## DECISION DELEGATED TO HEAD OF PLANNING

**Application No:** H20-0343-26      **Applicant:** Belmont UK

**Proposal:** Erection of 3 Dwellings - approved under H20-1258-25. Modification of Condition 1 to allow amendments to previously approved plans and removal of Condition 4 relating to Pilkington Privacy Glass

**Location:** The Orchards Broadgate Sutton St James

LOCATION & SITE PLANS

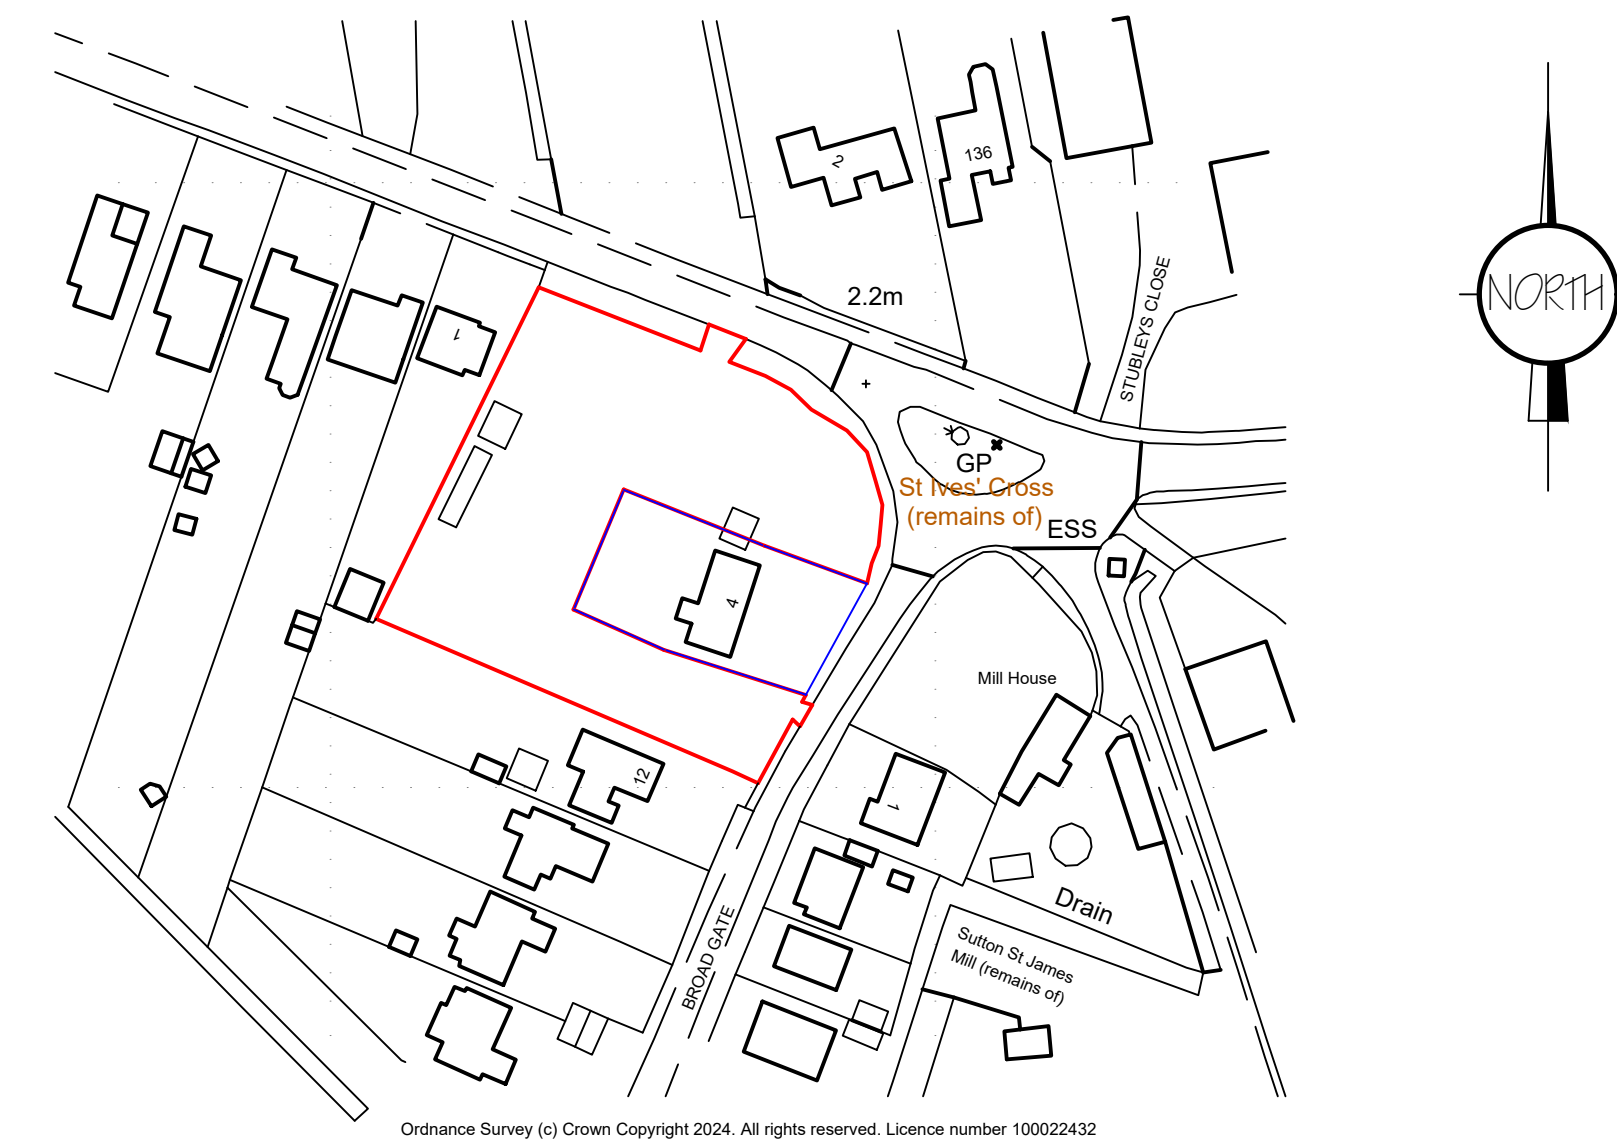
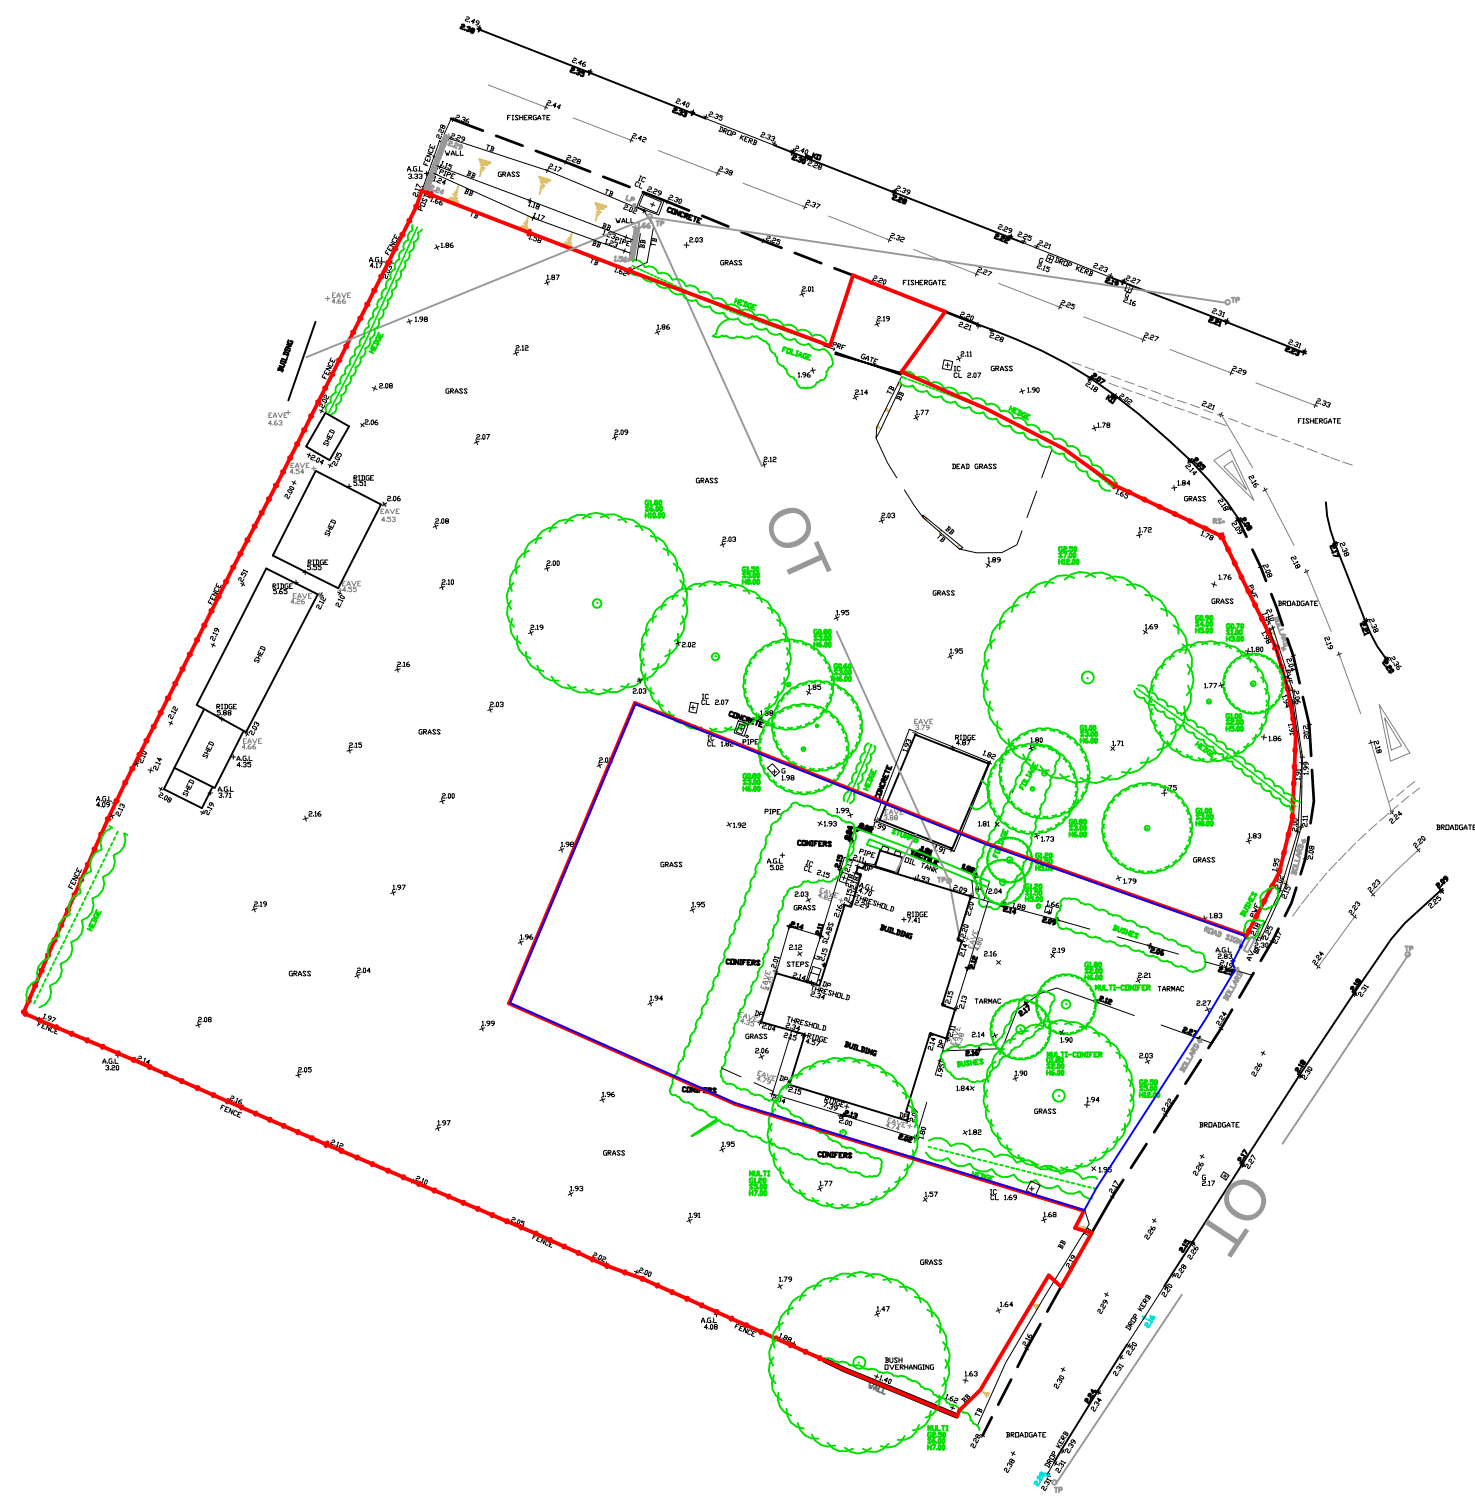
The current application seeks to modify the approved site plan and the plans for plot 1.

The current application also seeks to amend the site plan by making the garden for plot 3 approximately 6m longer at the rear of the plot. This would result in the loss of some of the garden space for plot 1; however, a very large garden would be retained for plot 1, providing occupants with ample outdoor amenity space. As such, the proposed lengthening of the rear garden of plot 3 is

Drawing: PLOT 3
FOUNDATION & SECTION

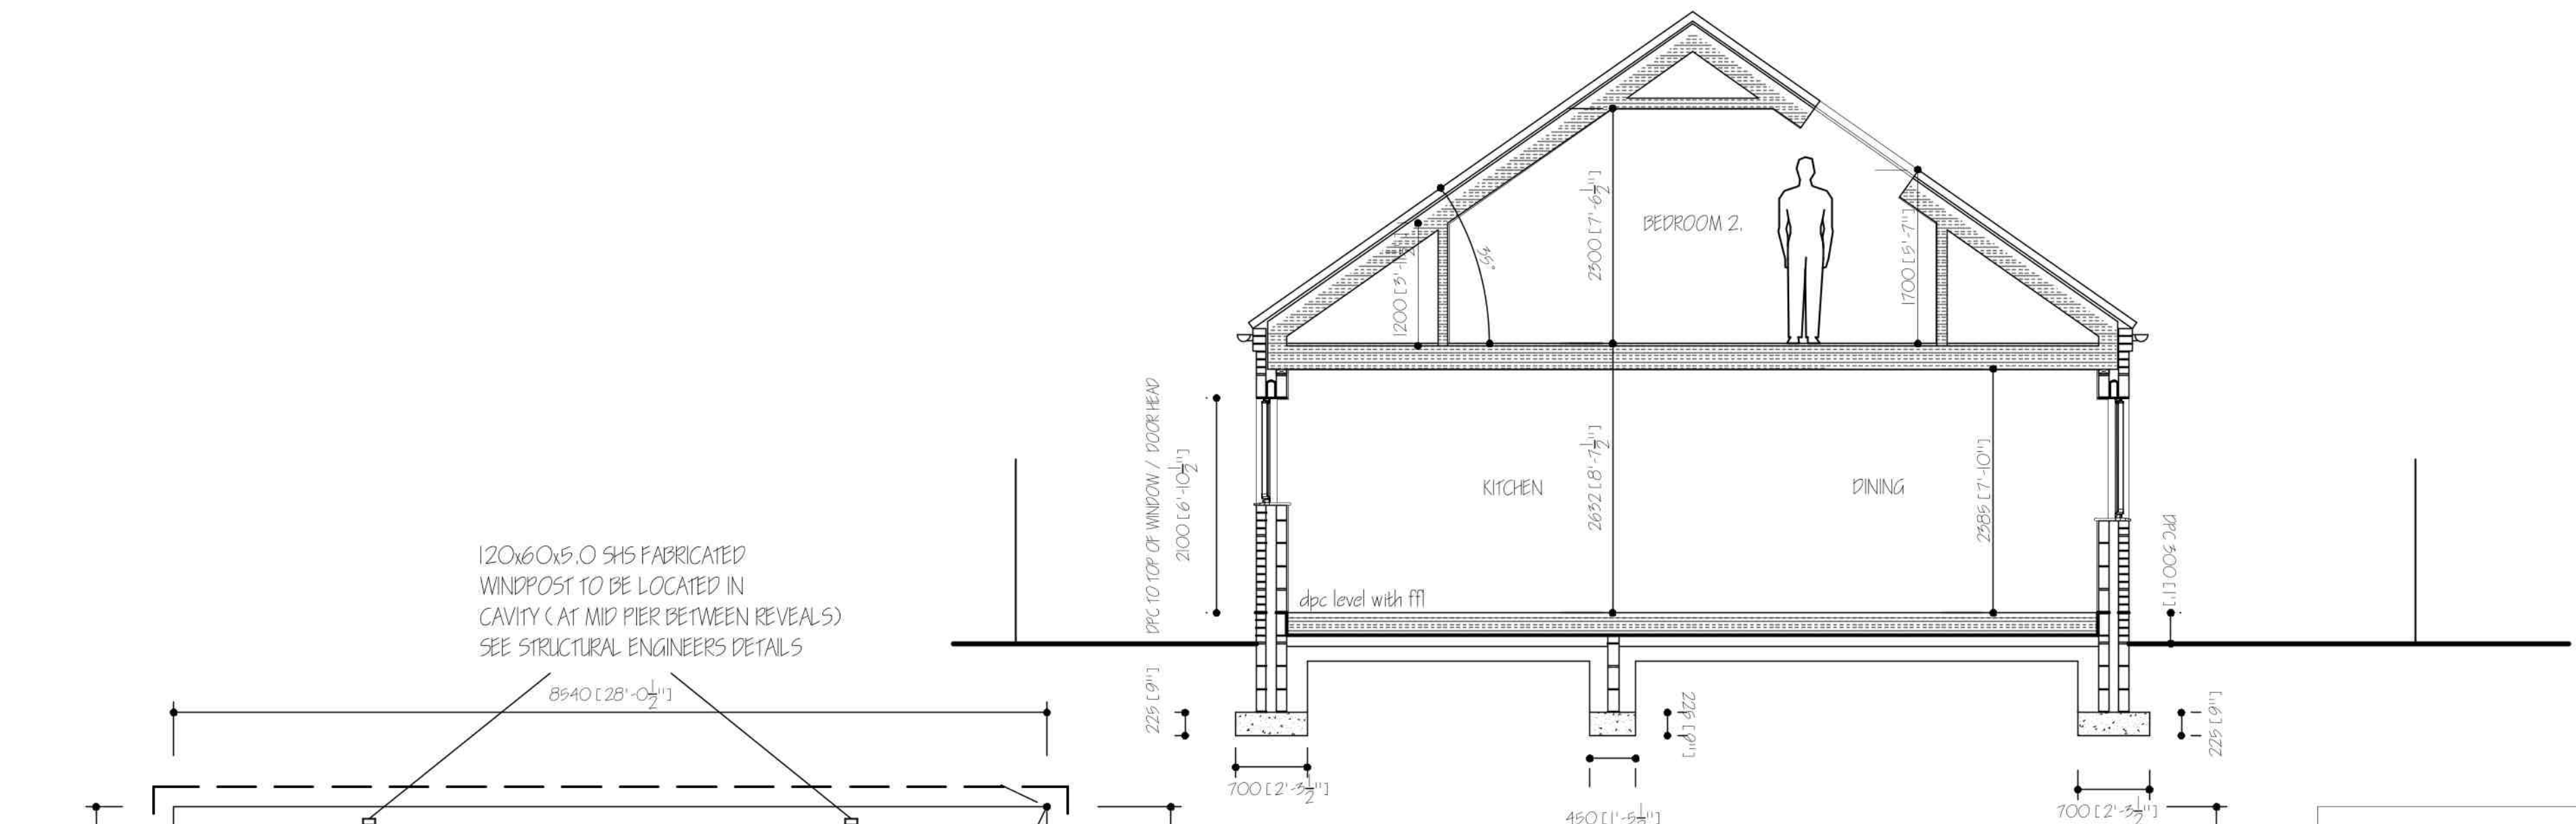
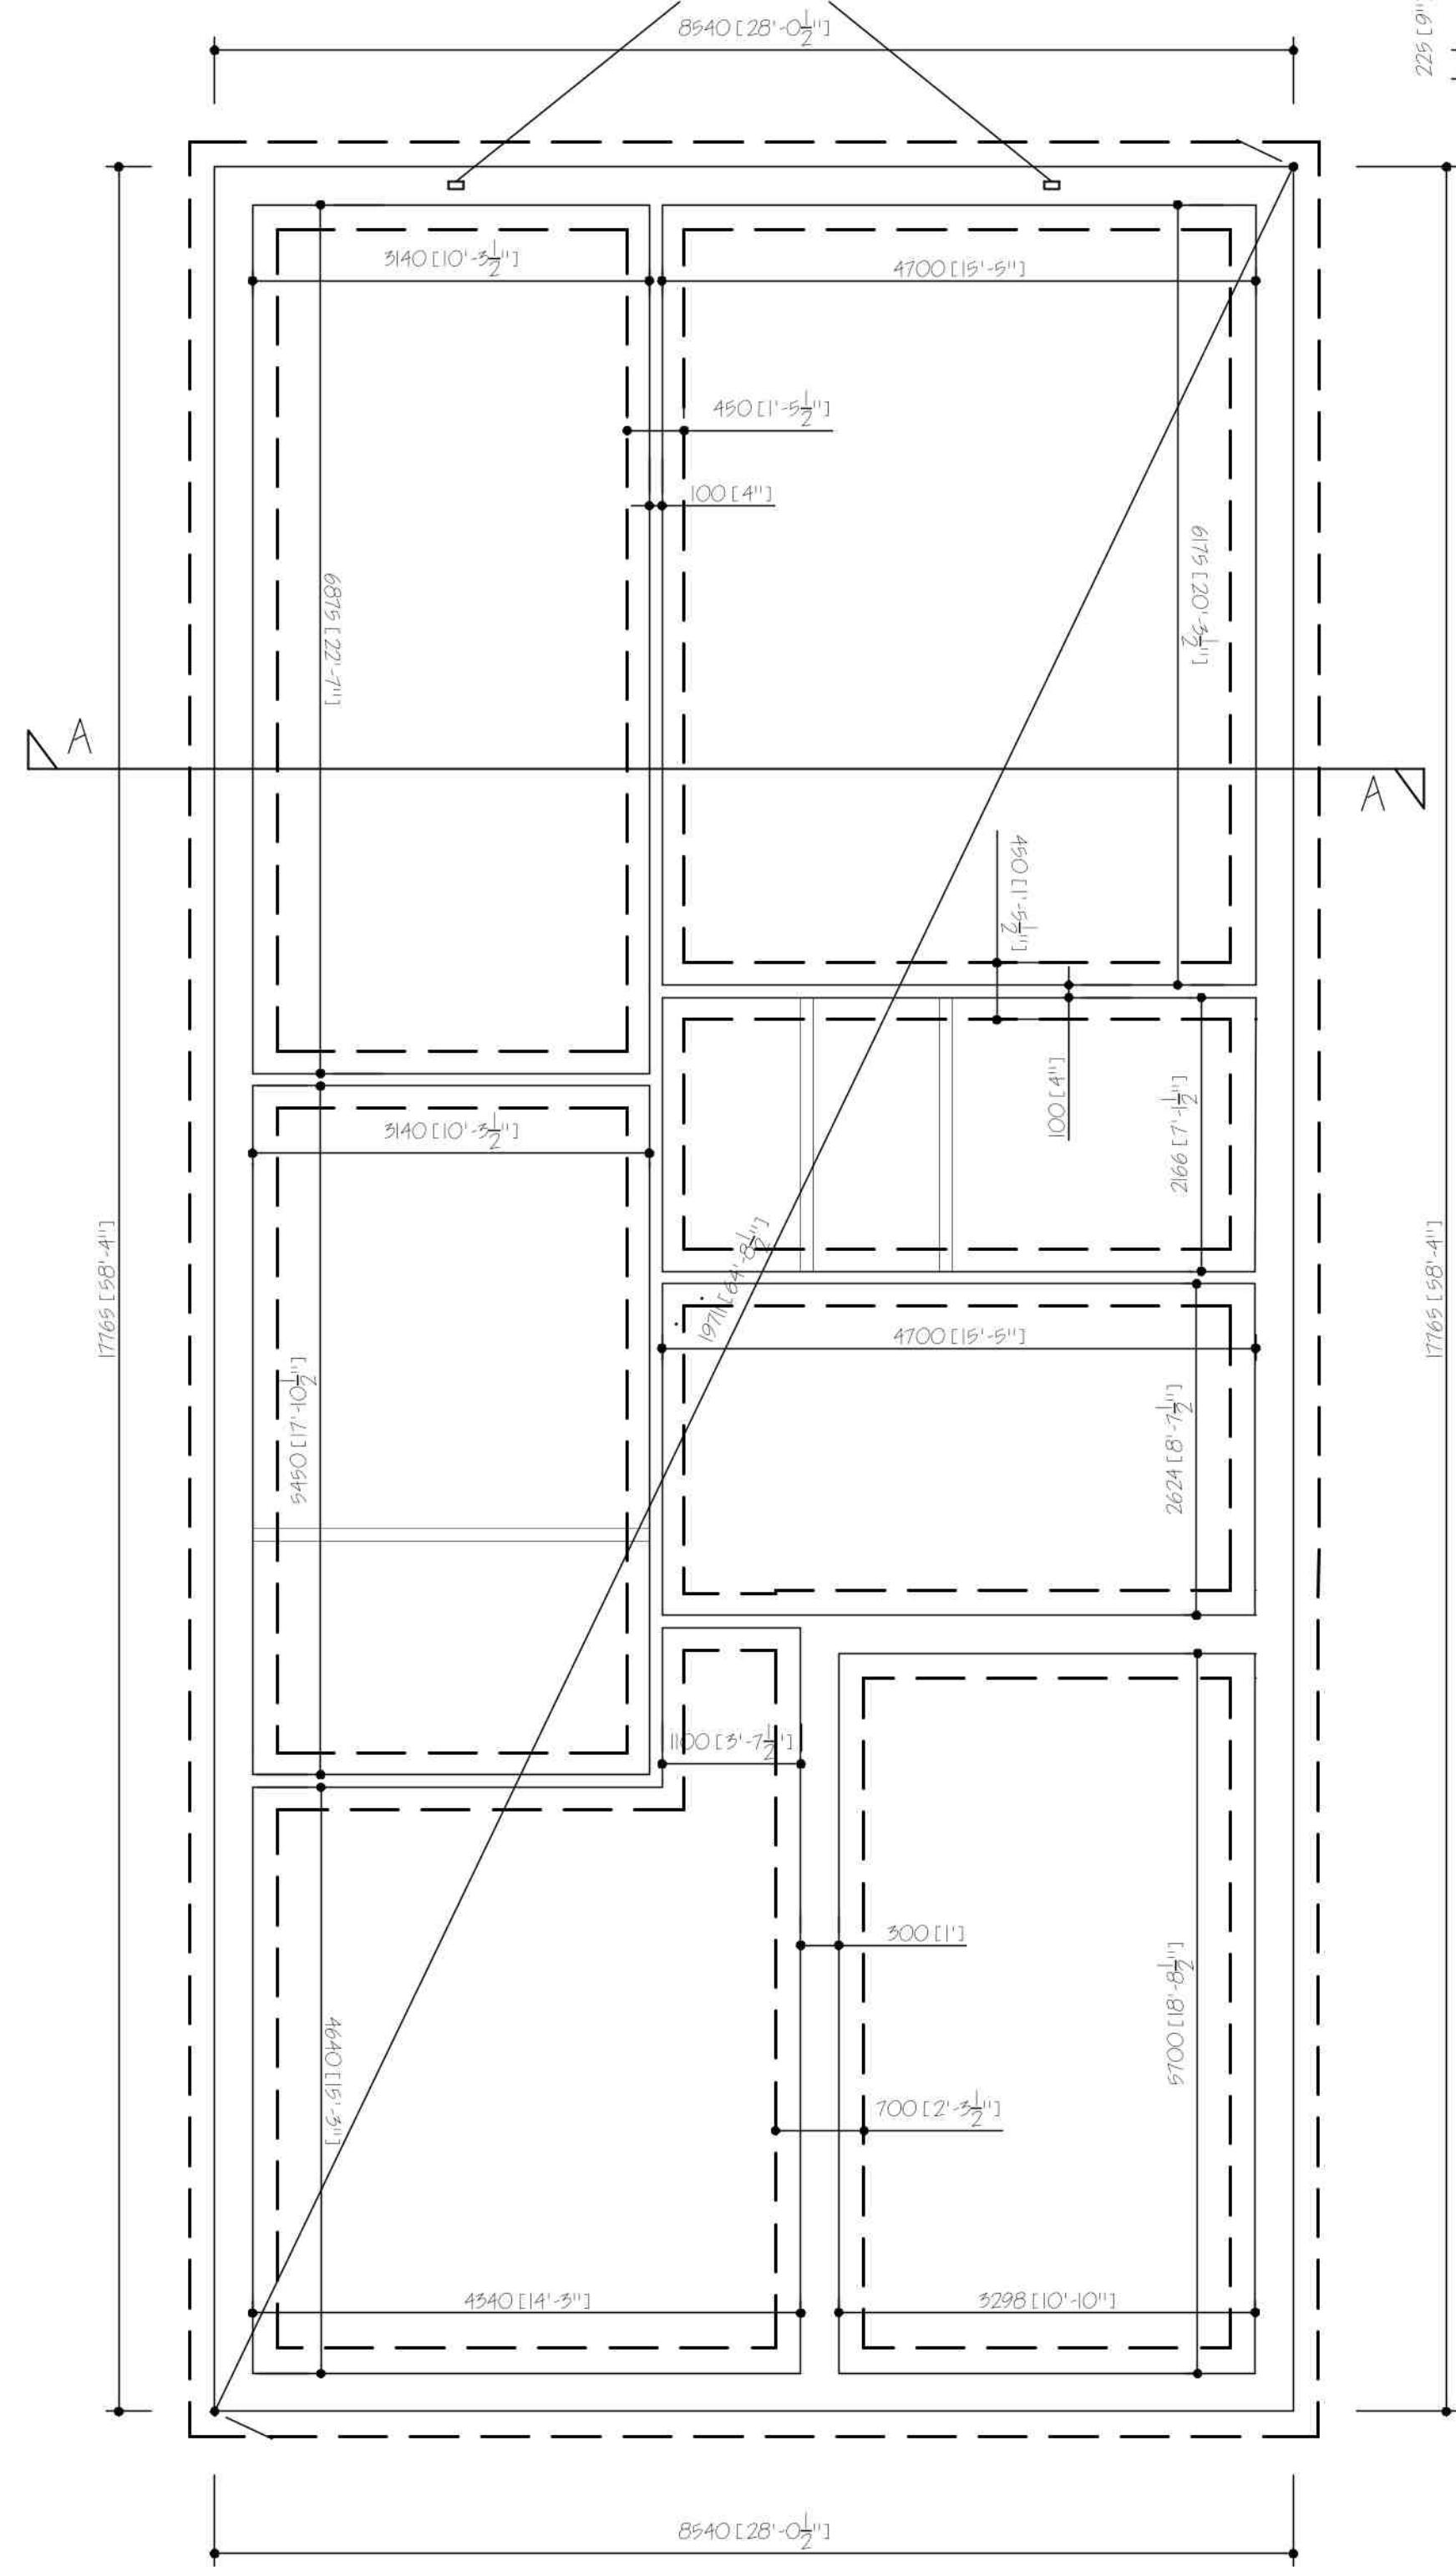
The southern side elevation of plot 3 is between 2m and 3m from the boundary with Homelea which is the nearest dwelling to the south. The planning statement refers to a property to the east; however, it is presumed that this means Homelea.

Although there is a close boarded fence between the dwellings, it is nonetheless considered that there would be a degree of overlooking if no obscure glazing is proposed. For example, there are habitable room windows proposed at the ground floor level including a kitchen and a playroom. The separation distances would be very small between the properties, and it is considered appropriate to retain the requirement for obscure glazing on these windows.

The planning statement sets out that only a very tall person would be able to see out of the room windows at the first-floor level. The LPA considers that 1.7m is not particularly tall and it is considered that occupants could see out of the windows. The roof lights would be approximately 5m from the site boundaries beyond which there are neighbouring gardens. As set out previously, it is considered that there should be a separation distance of 10m from habitable windows such as bedrooms and garden boundary to prevent an unacceptable degree of overlooking. The smaller separation distance was only accepted in this instance due to the inclusion of condition 4 which was considered a reasonable compromise and would have prevented the need for the applicant to completely revised the plot layout.
